**New High School in Bungendore (SSD-14394209)
Request for additional information**

The proposal was presented to the State Design Review Panel (SDRP) on 8 December 2021 (third review). You are requested to address the matters raised in the SDRP advice sheet dated 22 December 2021 (attached). Please include the response to these matters as part of the Submissions Report.

PROJECT: BUNGENDORE HIGH SCHOOL
RE: State Design Review Panel – 08.12.21 (third review)

6 Reinstatement of the Majara Street Alignment

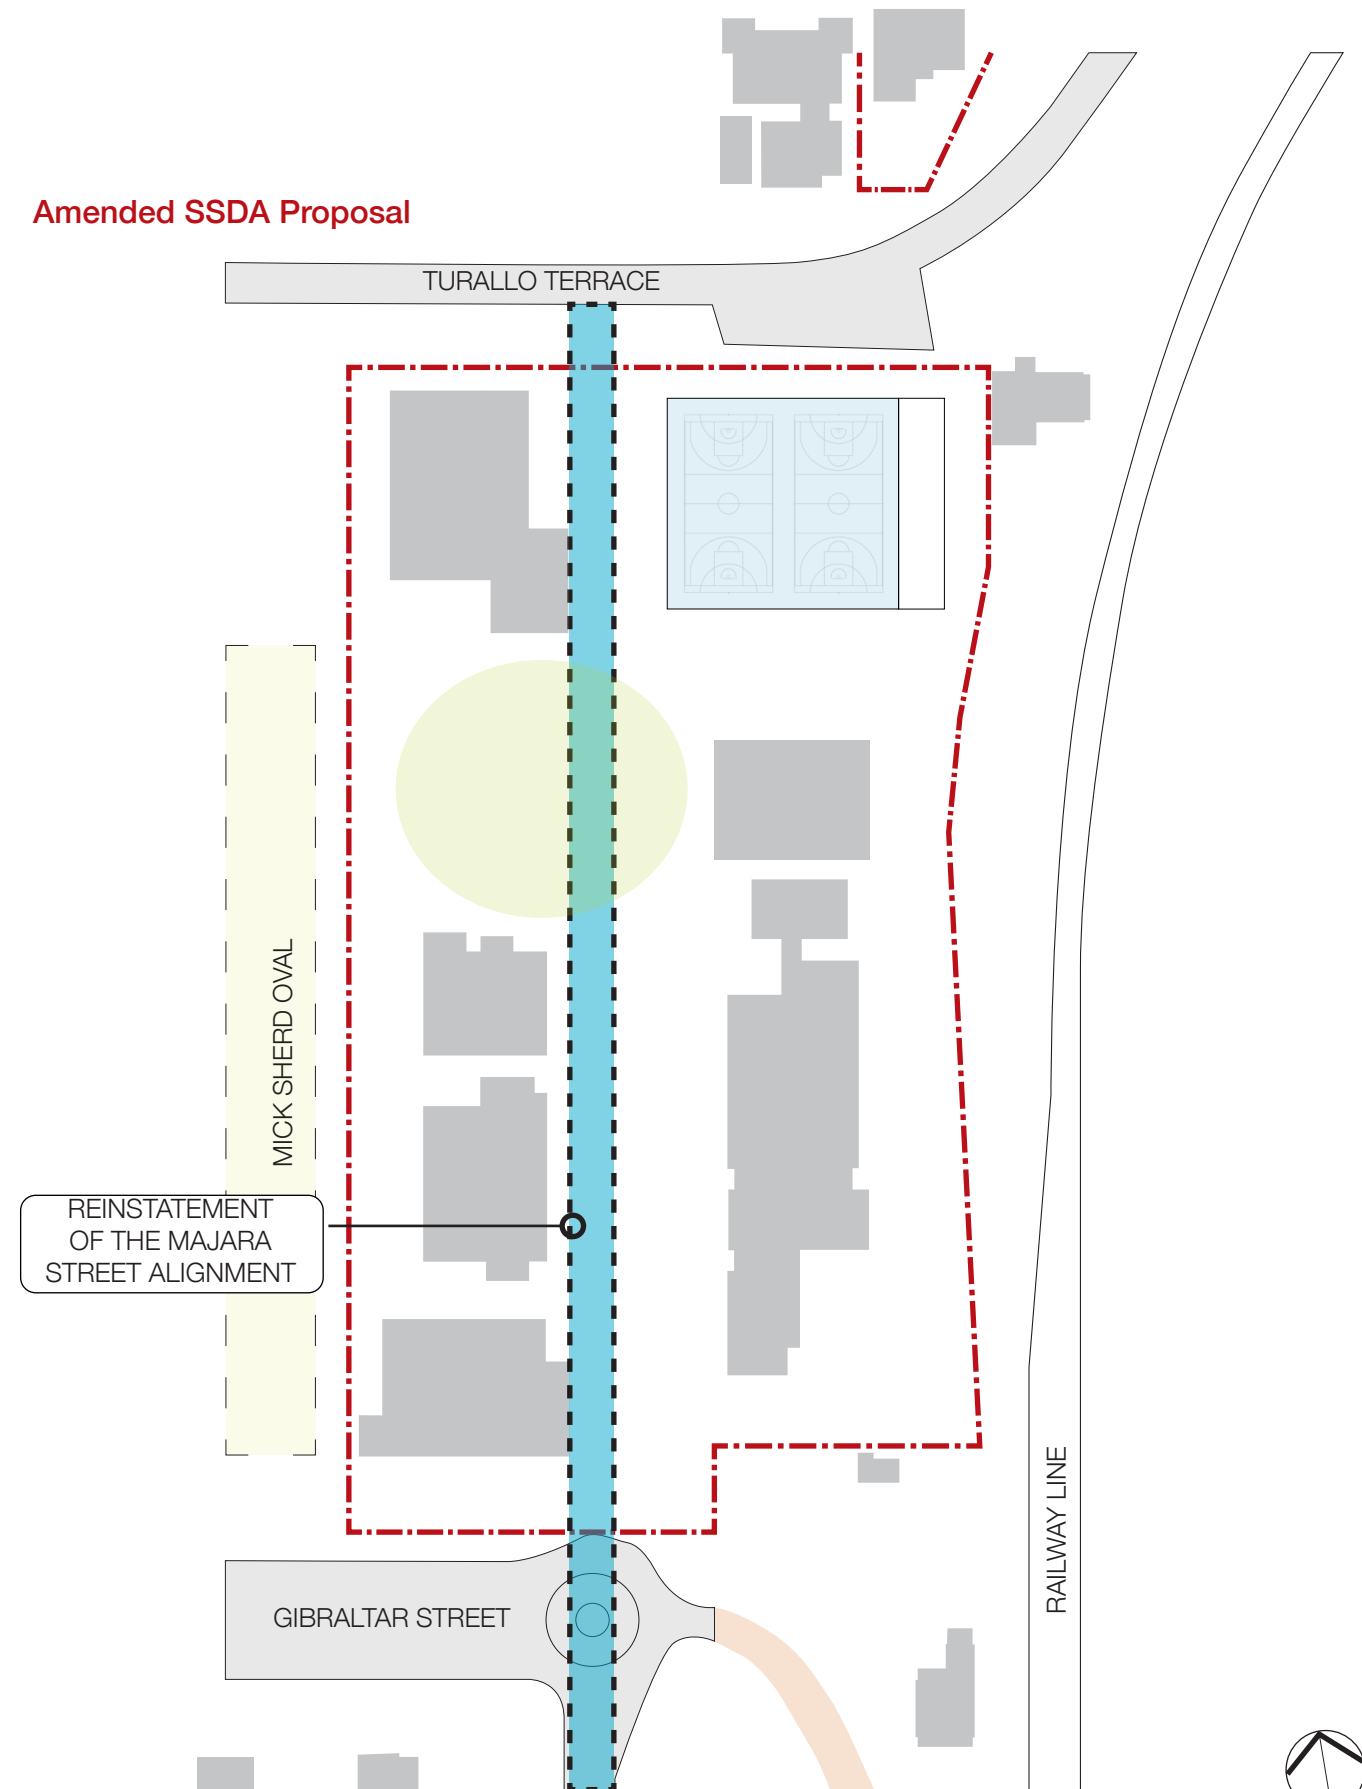
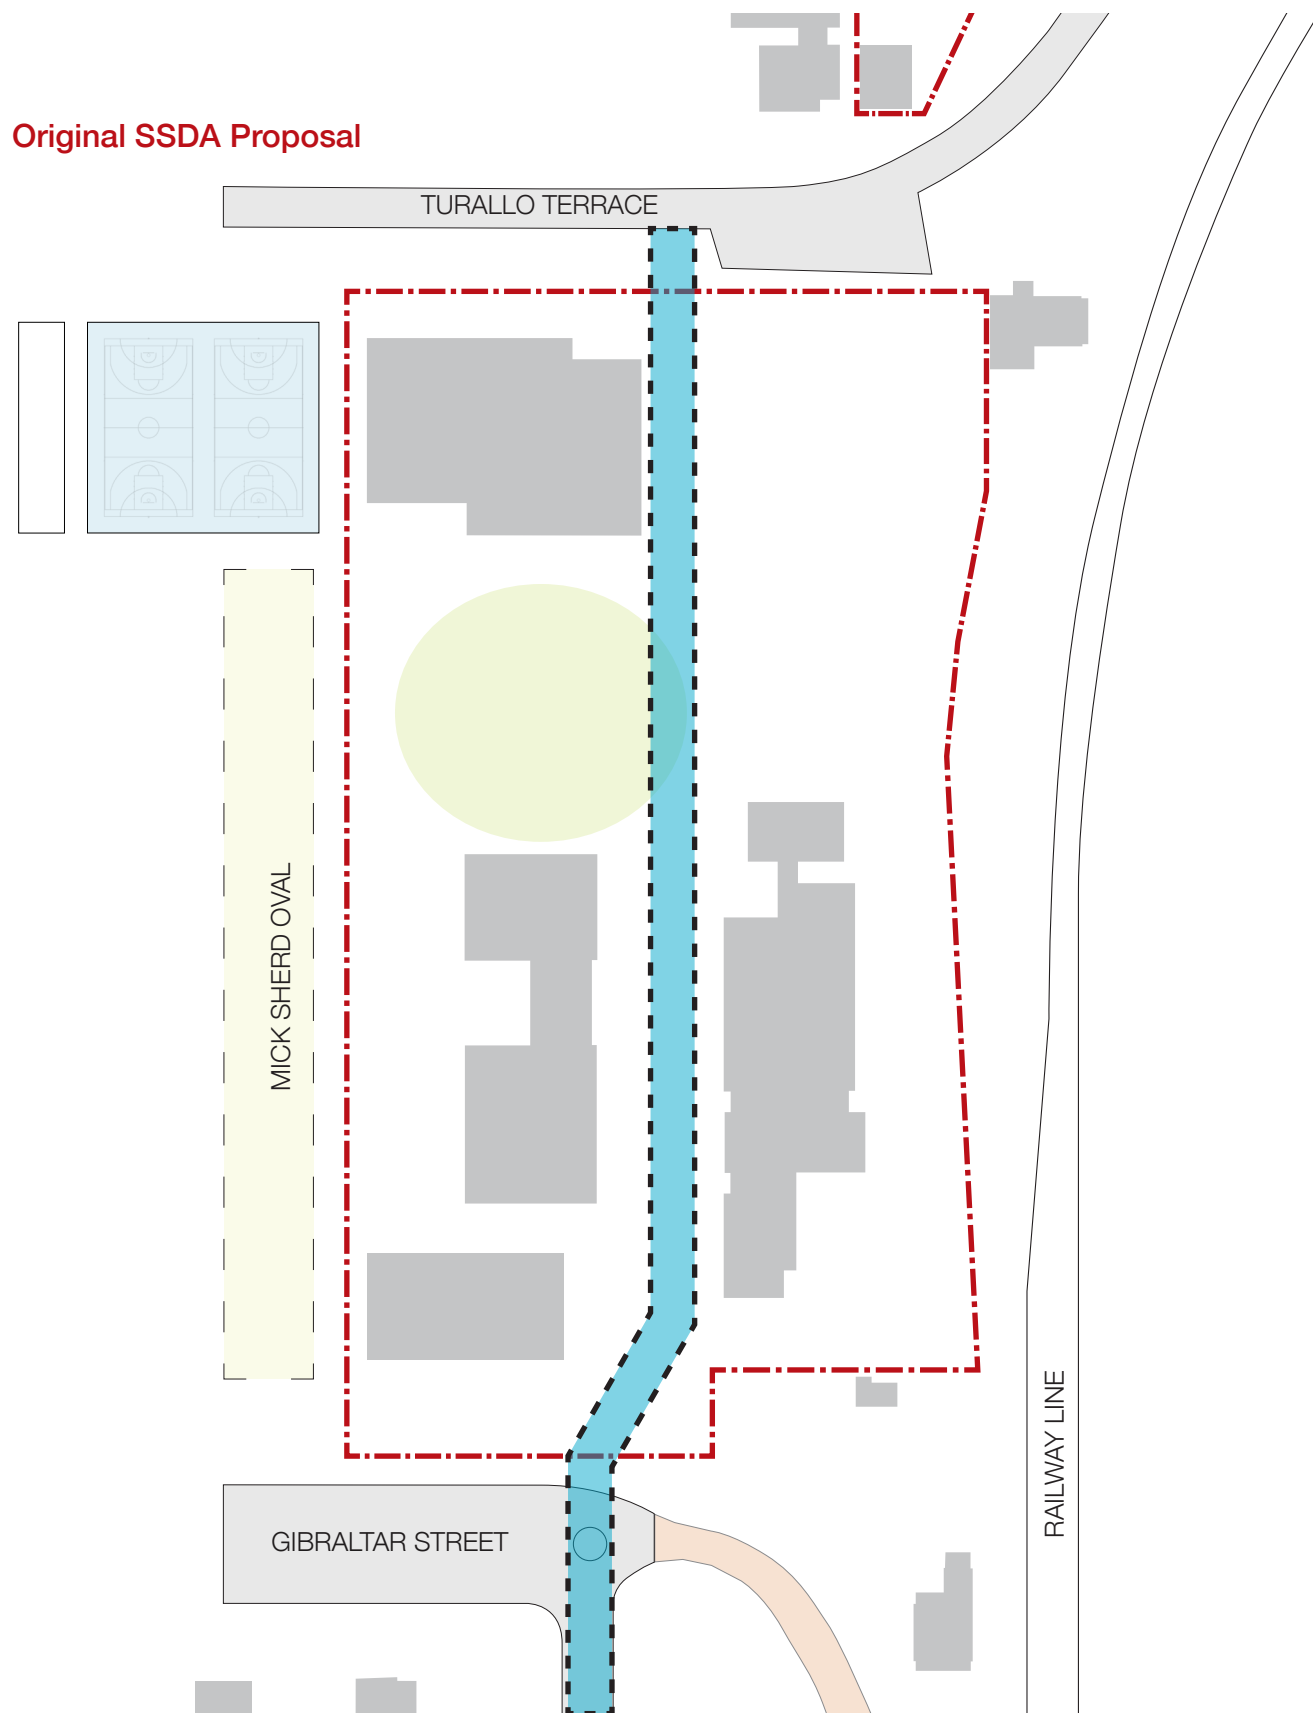
6. The erosion of the 19th century street grid is a major concern. It is recommended that the original alignment of Majara Street is reinstated and that proposed built form and open space support this gesture to maintain the integrity of the town plan. The proposed built form of the administration building, science, general learning and gym/library impede the original alignment. Consider relocating the built form further to the west and activate the Majara St plaza to create greater useable learning and open spaces.

11 Integration of Outdoor Learning Areas

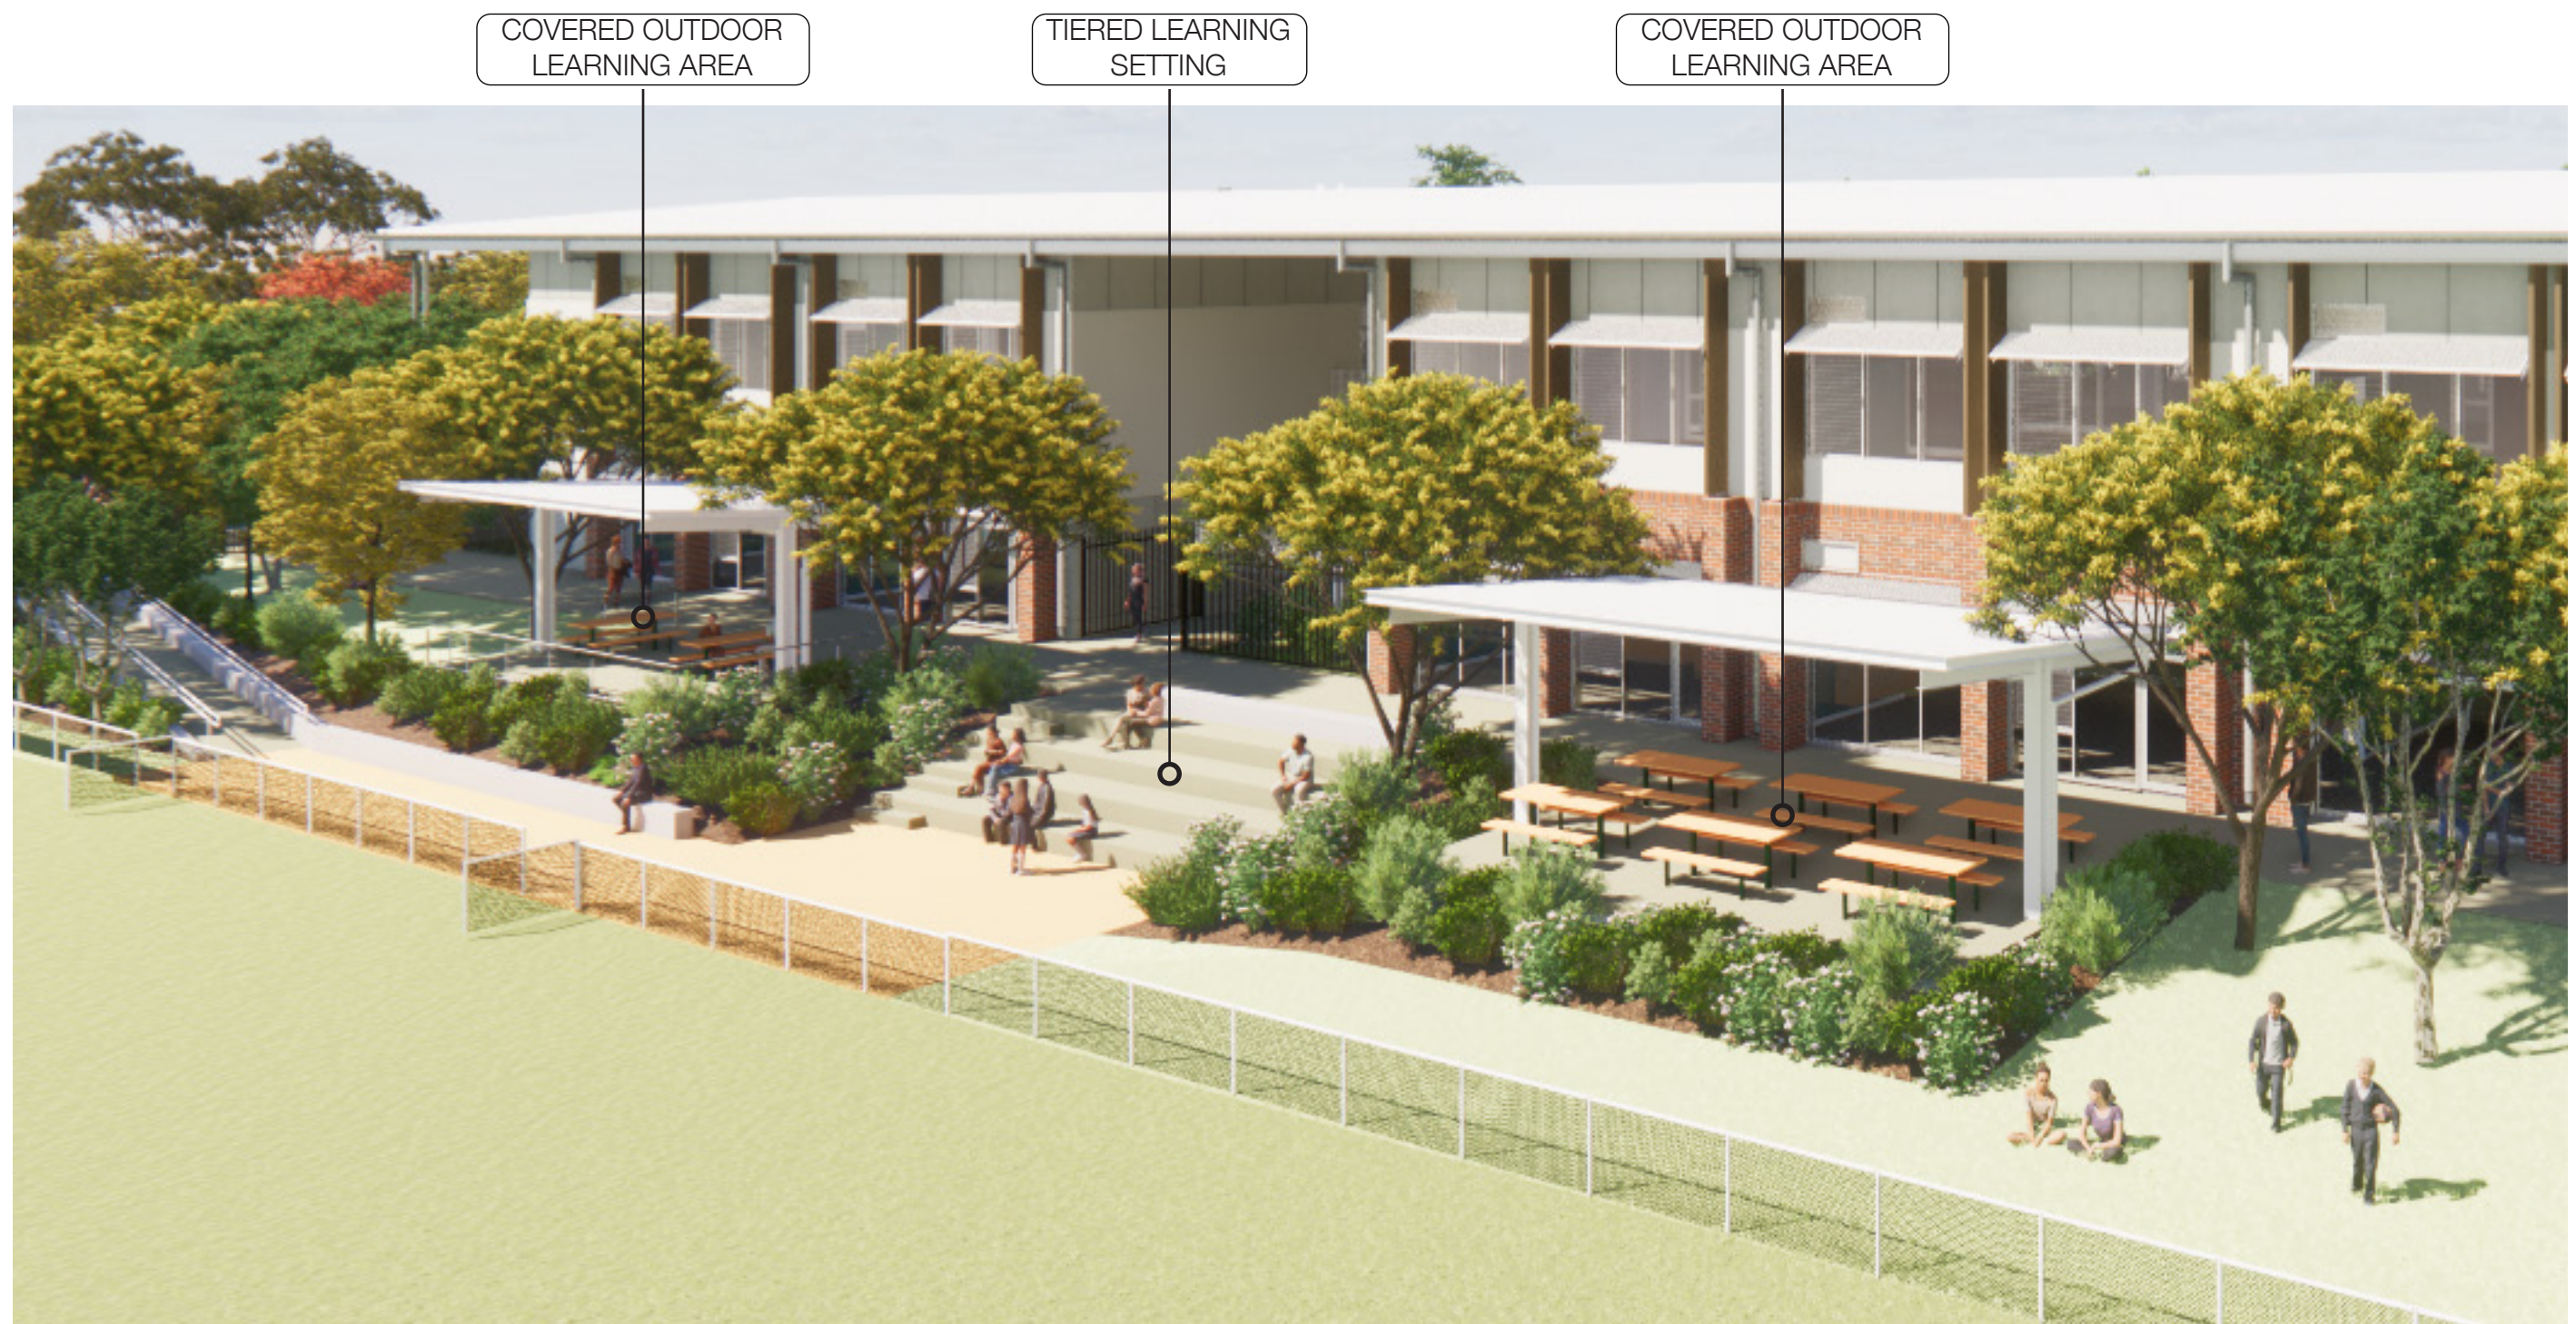
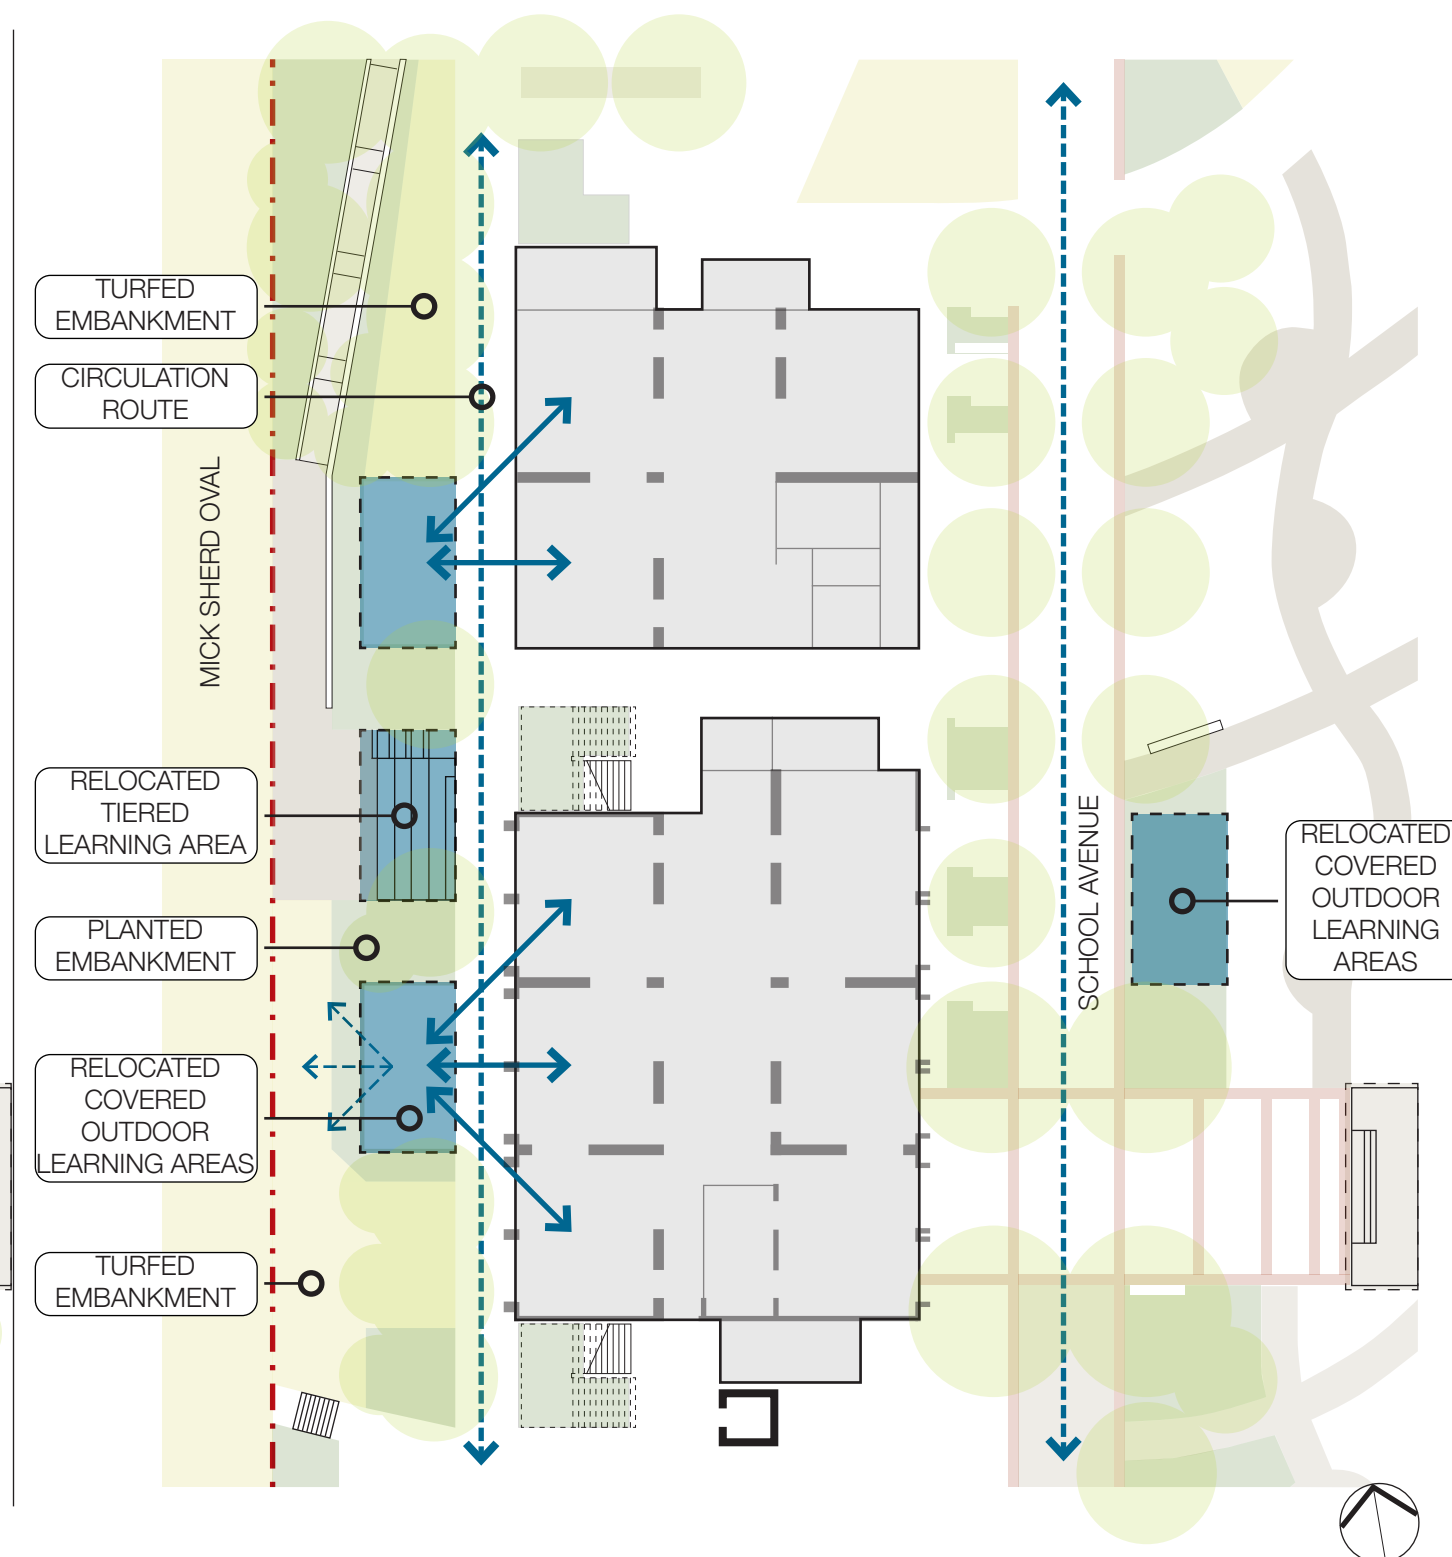
23. Provide increased protection to the western facades of the built form to assist in mitigating solar loads and increase cross ventilation.
24. Ensure that the built form and associated spaces have a clear hierarchy within the campus.
25. Remove the currently proposed outdoor marquees and replace with integrated covered elements.
26. Provide further detail on the spectator amenity and user experience to the areas adjacent to the Mick Sherb Oval. Provide details on how the spectator area will be used by the students and Bungendore community for different events.
27. Provide an update on the ESD strategy for the campus including the proposed implementation of sustainable design principles such as 100% photovoltaic electricity and campus wide water harvesting.
